From: Sue Howell
Sent: 14 August 2018 16:31
To: Michael Eastham
Subject: RE: Planning application ref - AL/20/18/OUT

Sue Howell | Leisure and Landscape Officer, Greenspace, Engineering and Emergency Planning, Arun District Council | Location: Bognor
Regis Town Hall, Clarence Road, Bognor Regis, West Sussex, PO21 1LD

Figure 4.1 – Illustrative Site Plan

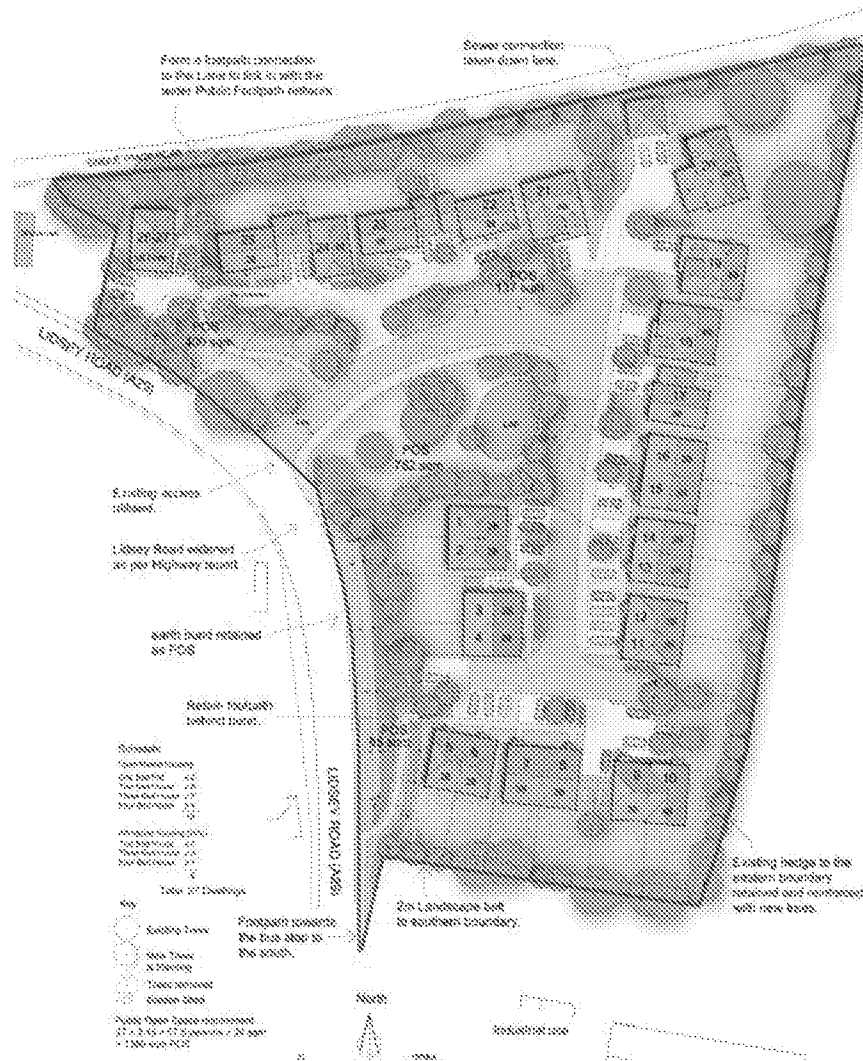
Happy with the open space proposals and play offer

LEAP would be considered slightly closer to plots 8-9 than ideal, but LEAP could be tweaked at a later stage to adjust positioning of this.

No landscape objection to the proposals as submitted.
